Preferred Project Report

Block 3B, 3C and 10 Kensington Street

Student Accommodation and Ground Floor Commercial Use

Submitted to Department of Planning and Infrastructure

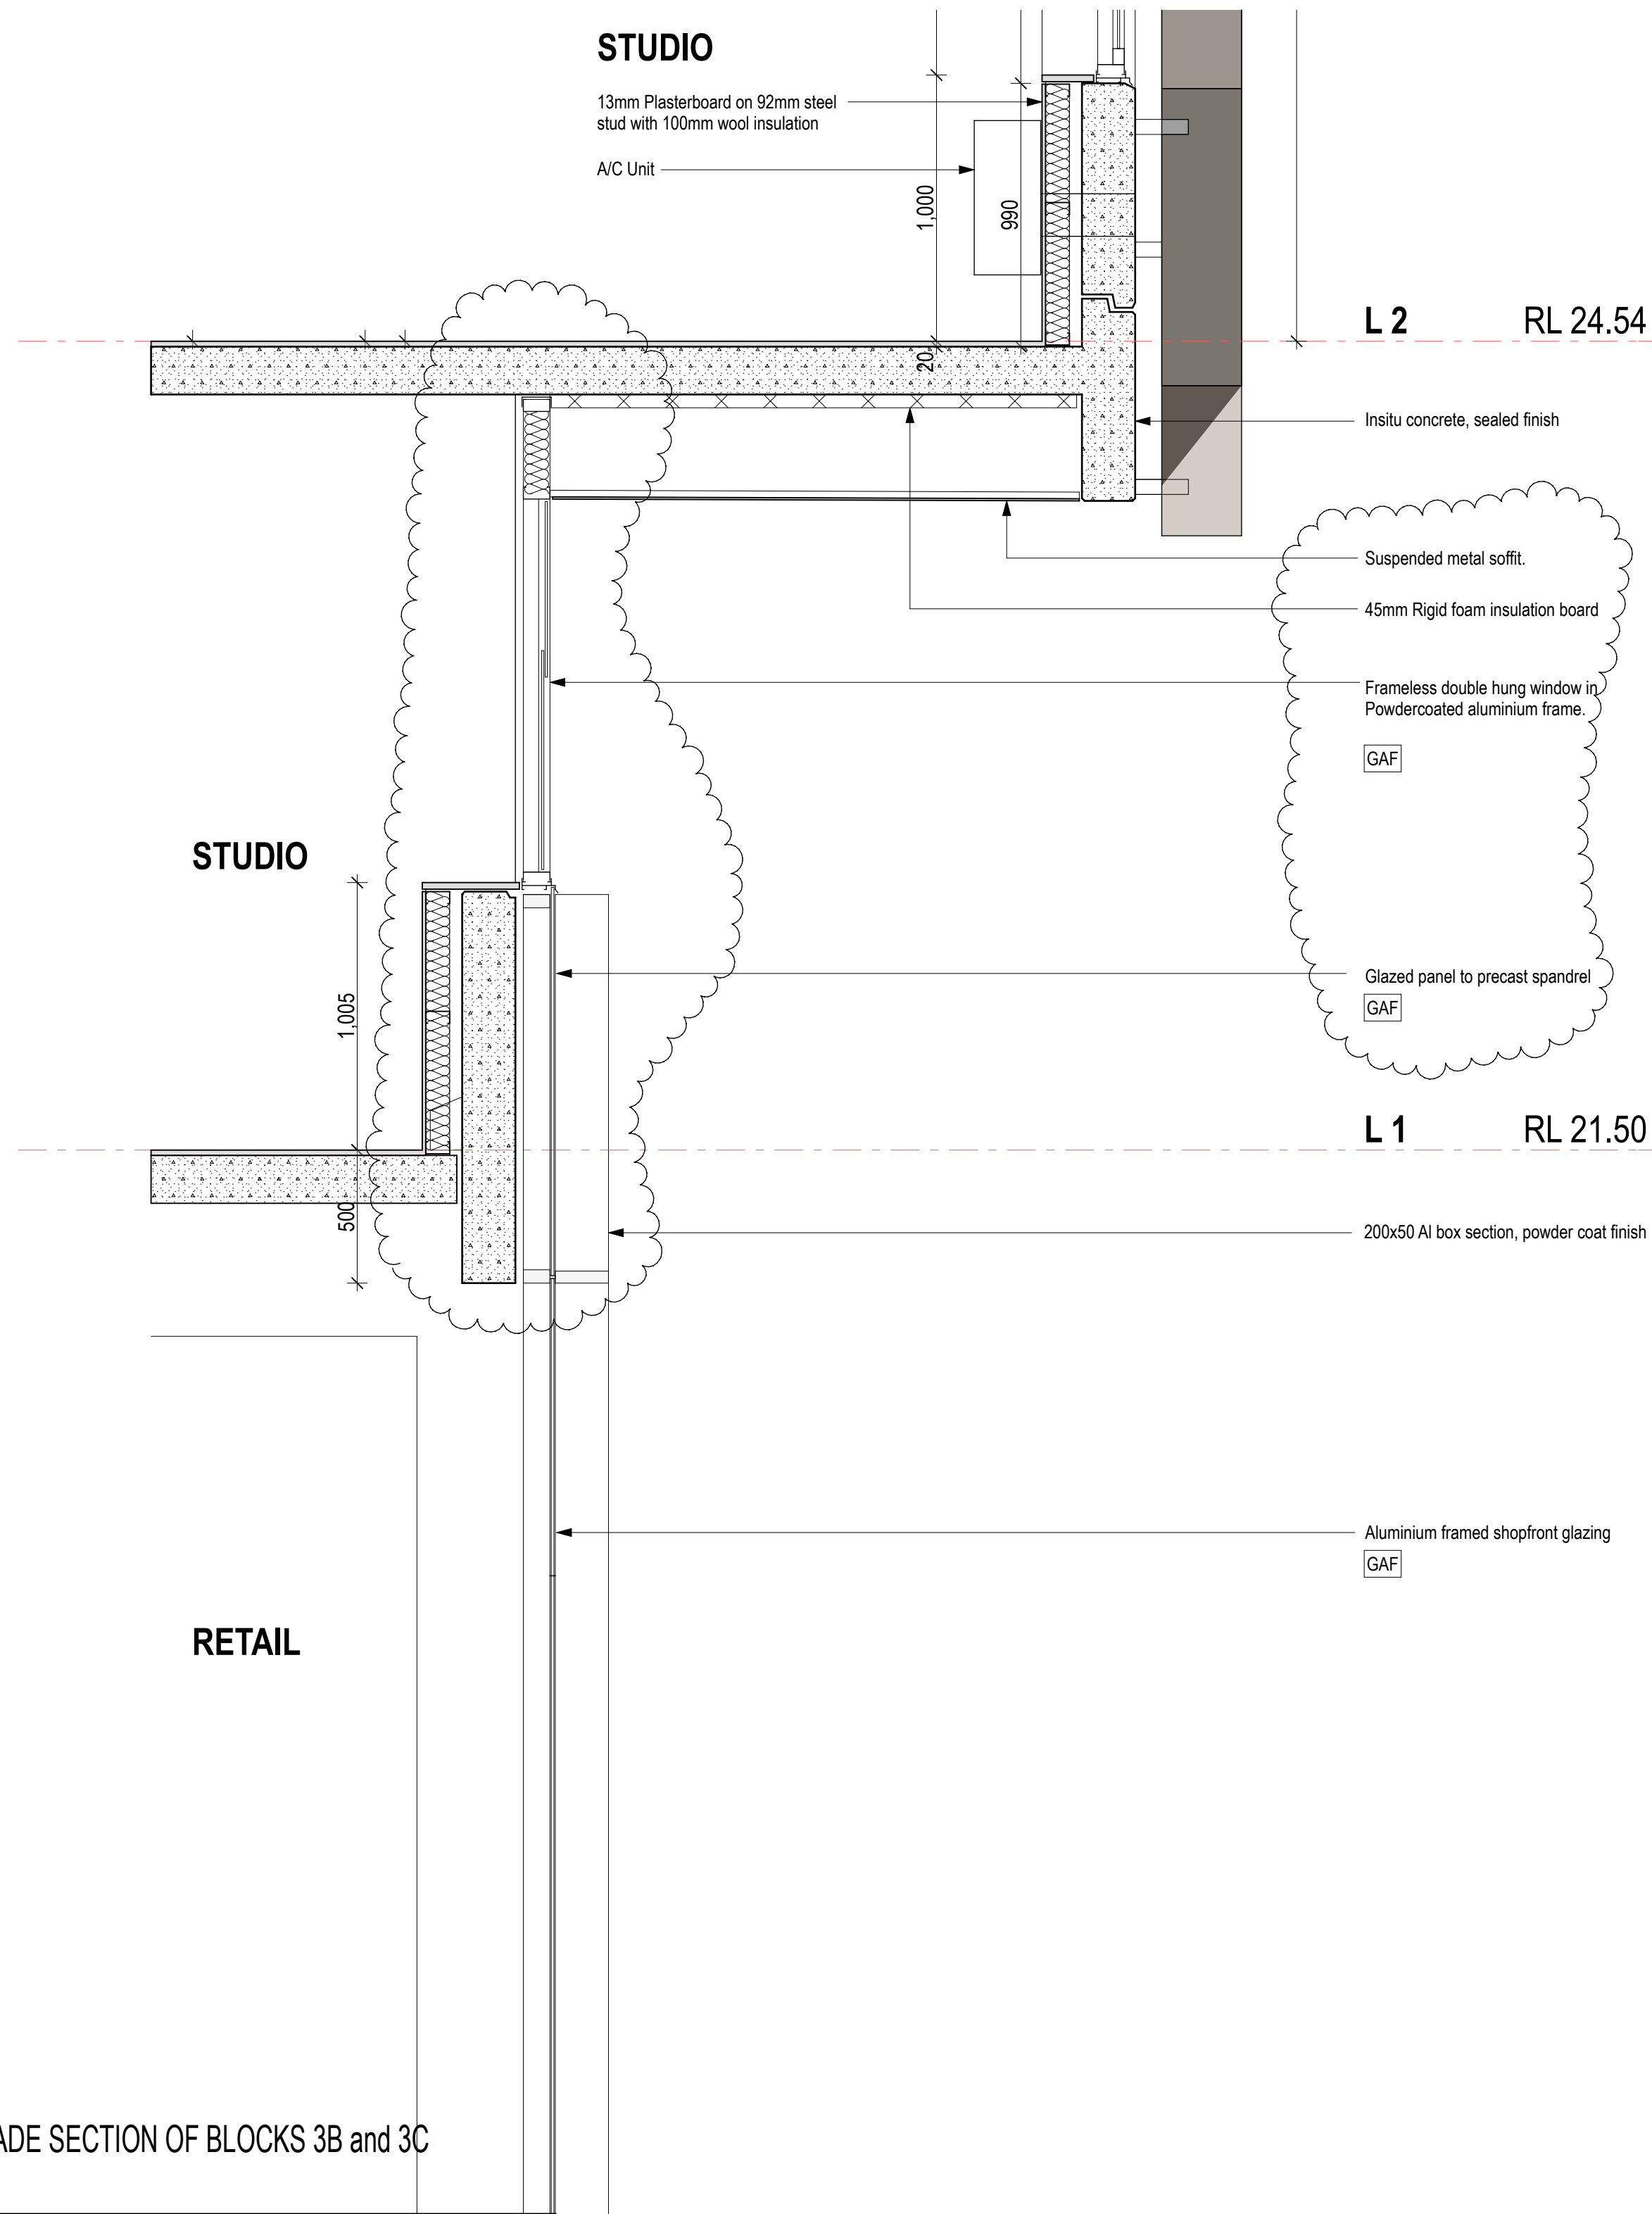
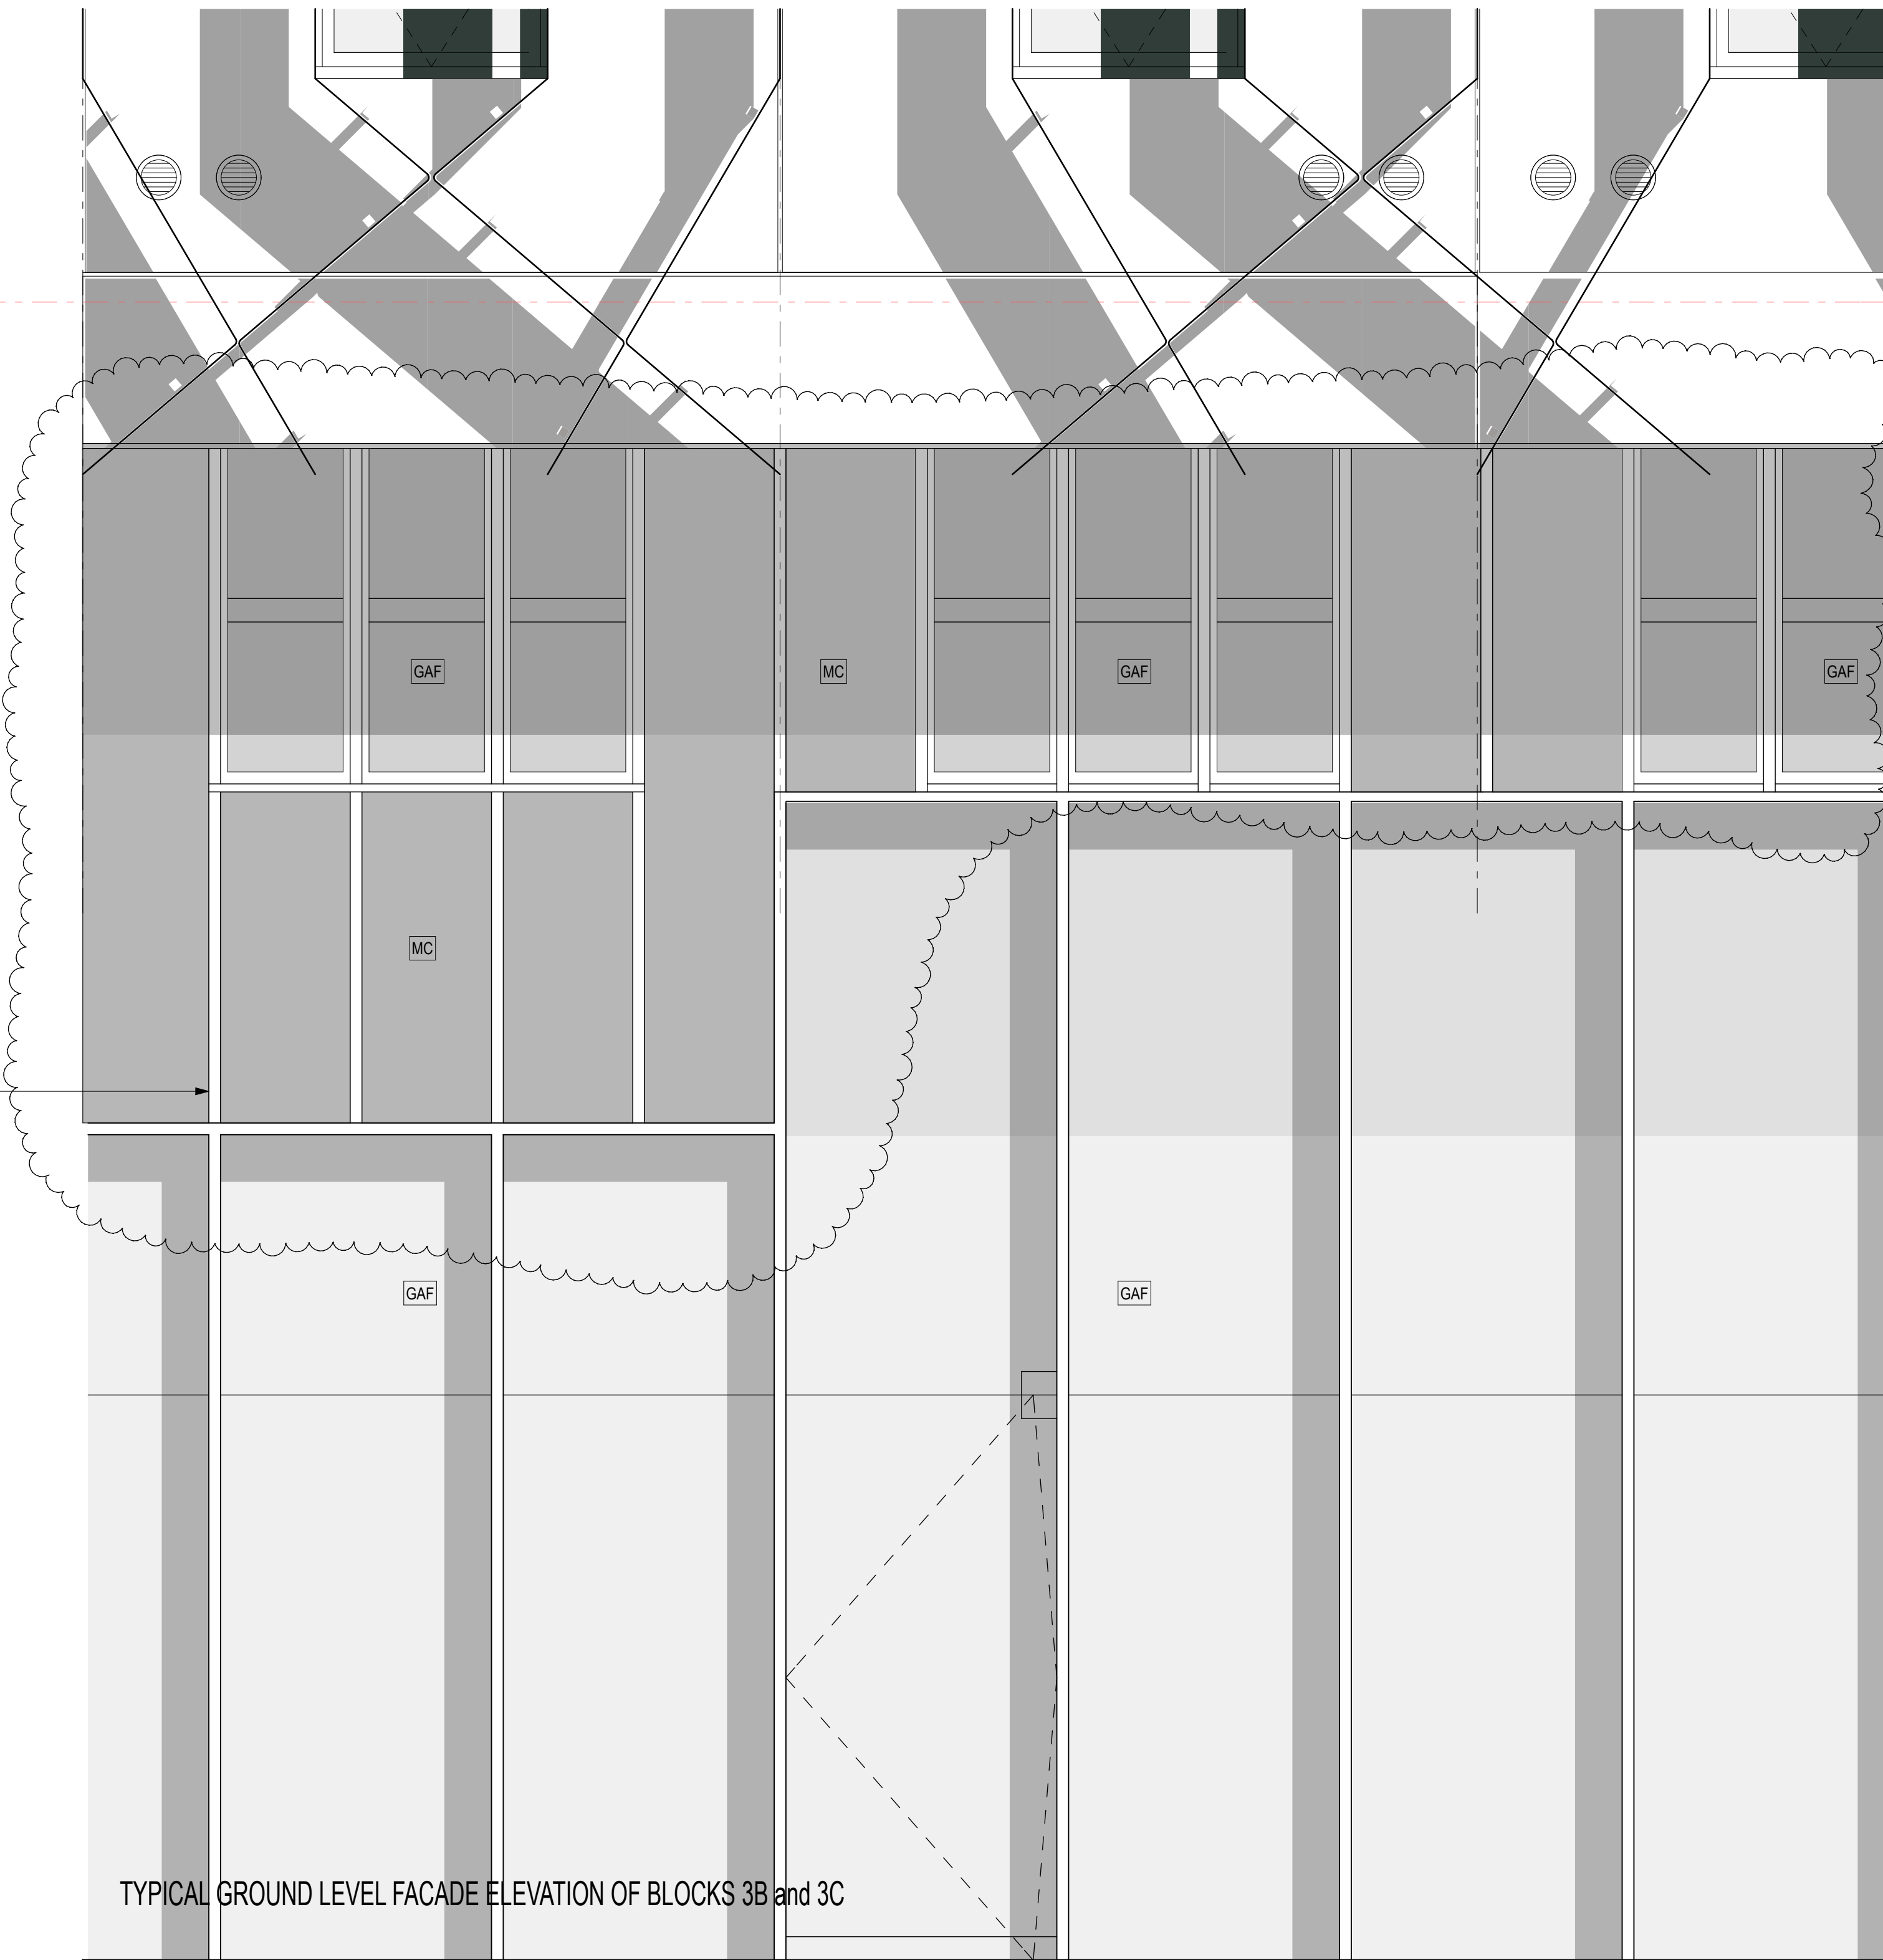
All windows within the cluster rooms and studios will be operable. These windows will function using an operable pivot friction stay hopper with restrictor system. The details of these windows are shown on revised plans A-601 at **Appendix A**.

- Shop front glazing to Kensington Lane has been articulated by a 200mm deep externally placed aluminium frame, creating a third, stepped element with a compatible scale to the terraces on the opposite side of Kensington Lane (see Plan A-601 and A-602).
